Subject: **Review of Plans and Response to Geotechnical Review Comments**
Proposed New Residence
6950 Southeast Maker Street
Mercer Island, Washington

Reference: Geotechnical Engineering Study, same project; Geotech Consultants, Inc.; March 21, 2022.

SHORING PLAN
SCALE: 1/4" = 1'-0"

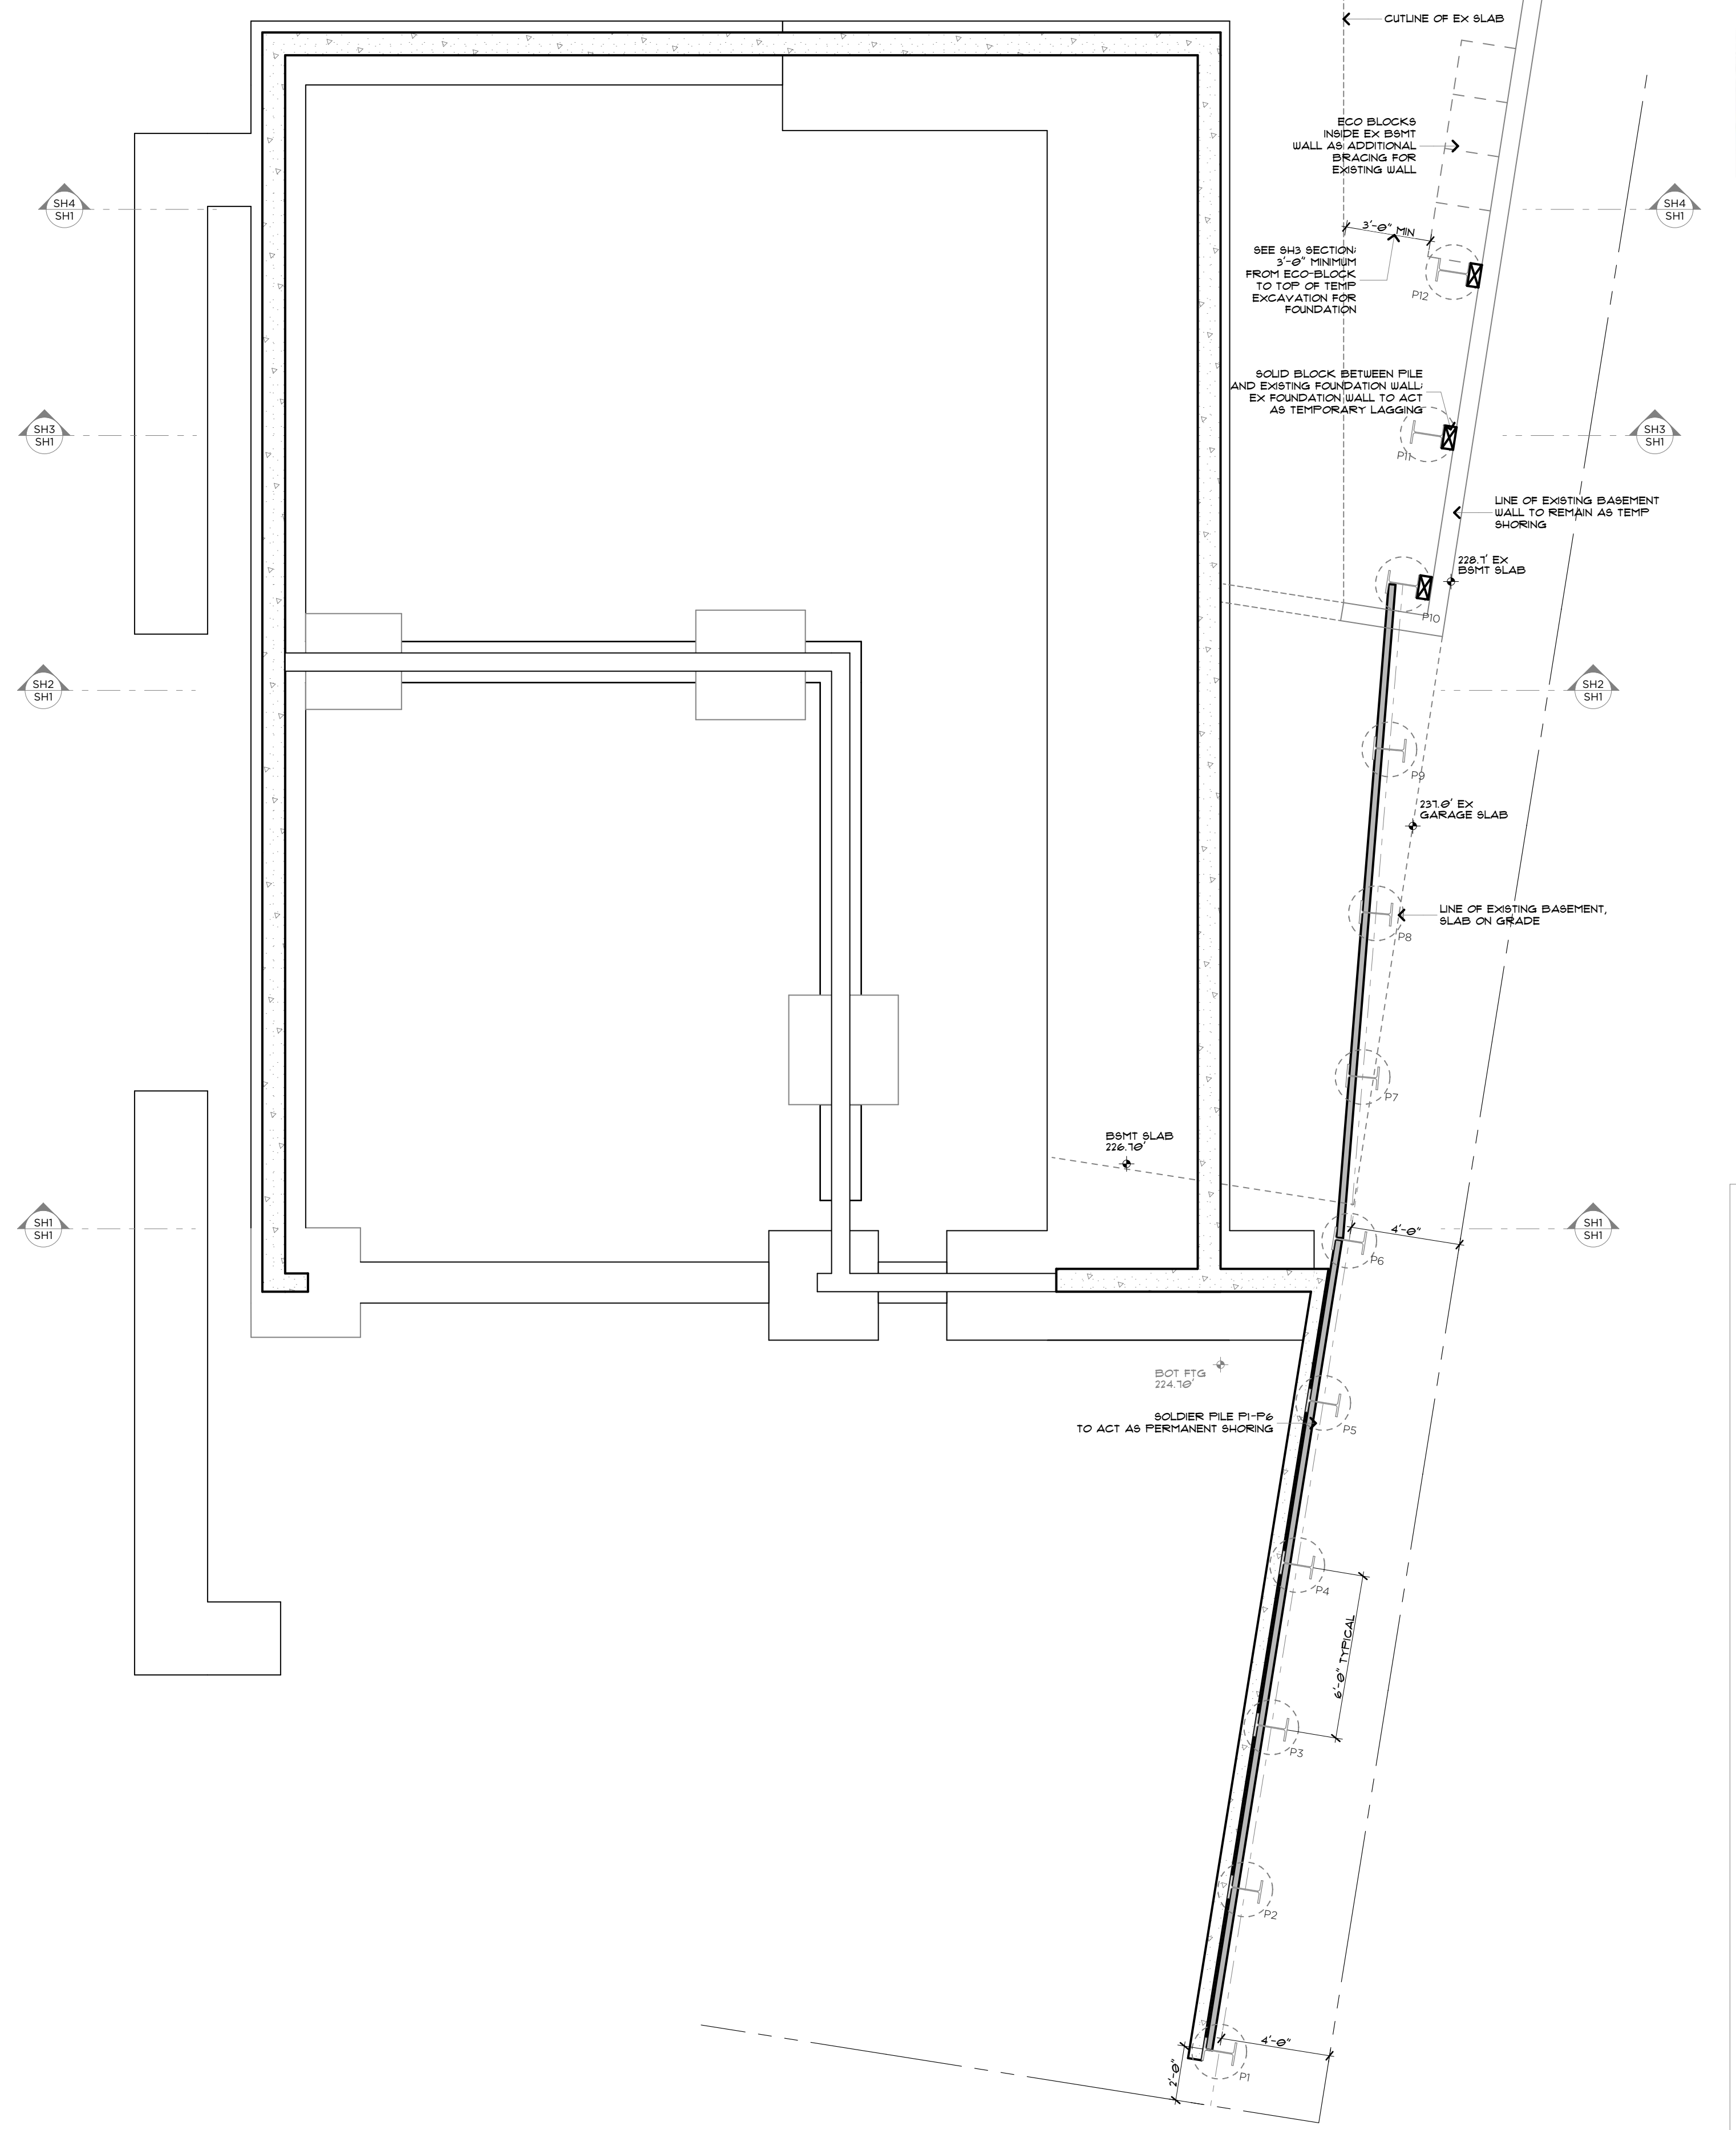
The foundations for the new residence will bear on dense glacial till soils. Cantilever soldier pile shoring has been incorporated along the eastern, upslope, side of the excavation for the driveway and the southern portion of the house. The soldier piles along the driveway, to the south of the house, will be faced with concrete and will provide permanent support. The existing basement wall of the current house will remain in place to provide excavation shoring north of the soldier piles. The excavation shoring is shown on sheets SH1, SH2, and C-2.

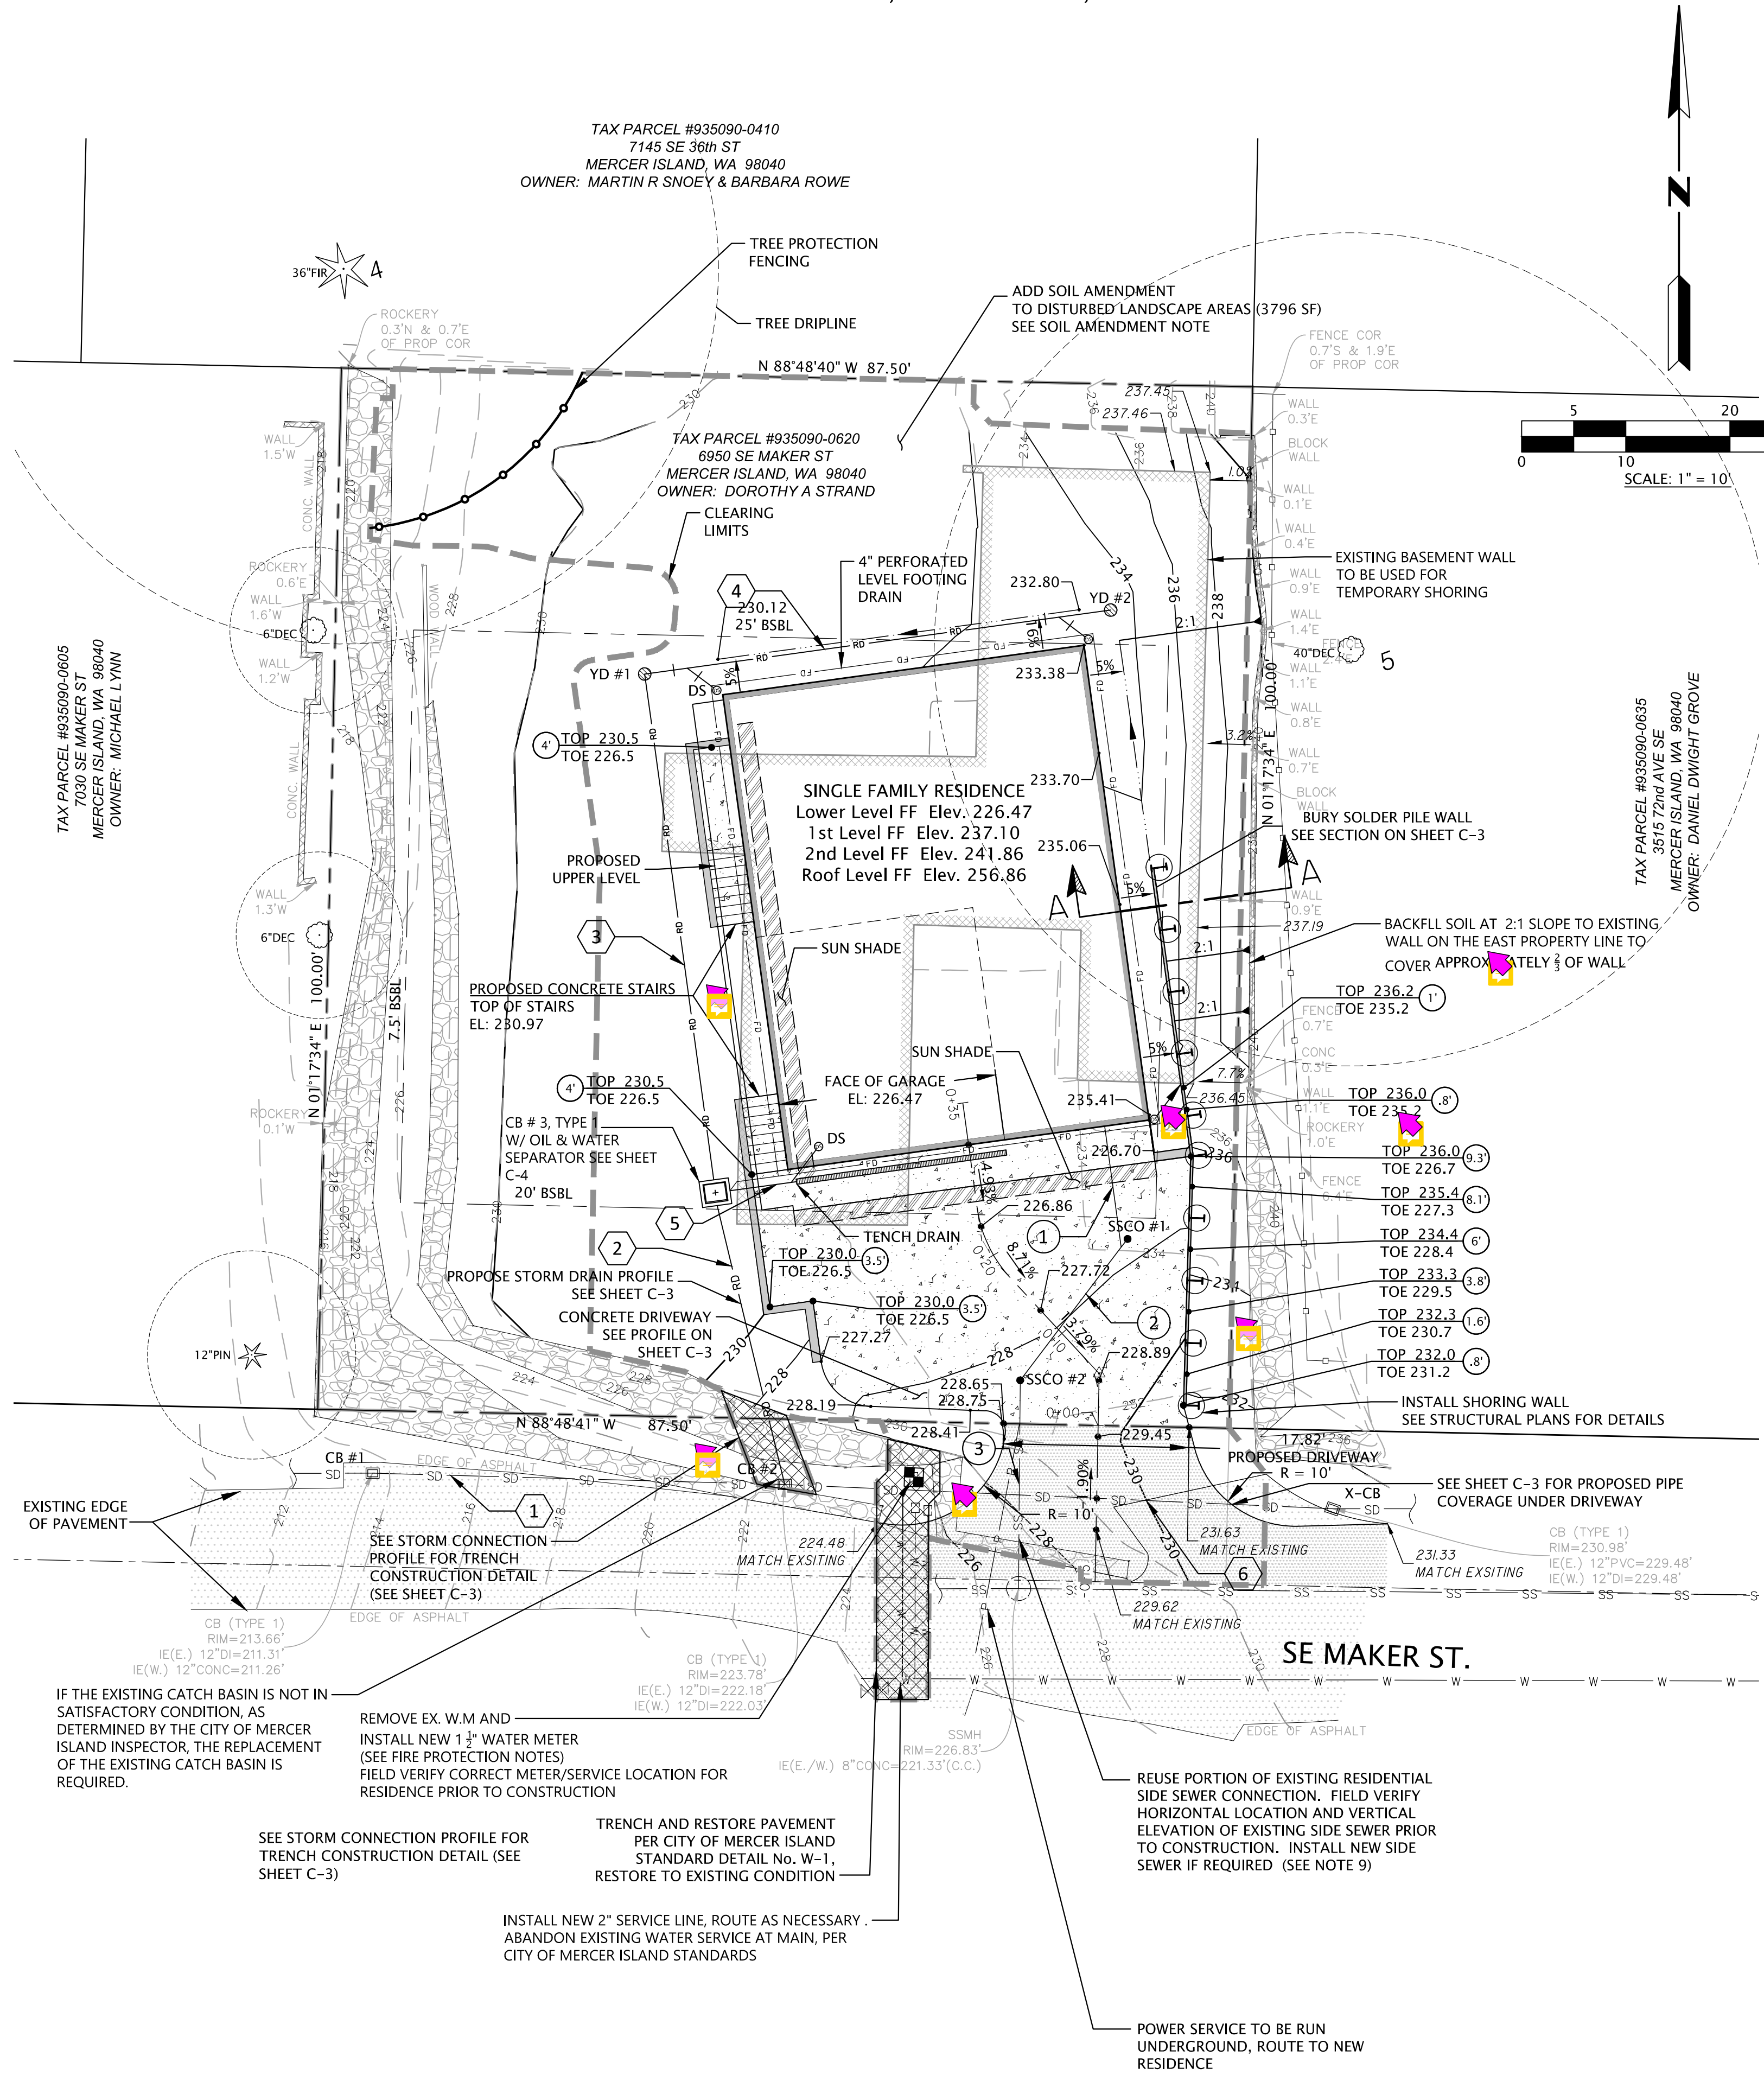
As depicted on sheets C-2 and C-3, the eastern basement wall of the new house will be backfilled to provide permanent lateral support, with the backfill sloping up to the face of the lower wall located at the eastern property line. This is intended to provide appropriate permanent stability for that wall.

A new storm drain will be installed to the west of the house, extending southward to Southeast Maker Street. In order to install this storm drain, a section of the 4-foot rockery located along the southern edge of the lot will have to be removed and be rebuilt. This is illustrated on sheets C-2 and C-3. Removal and proper reconstruction of this small section of rockery will not adversely affect stability of the site or neighboring properties.
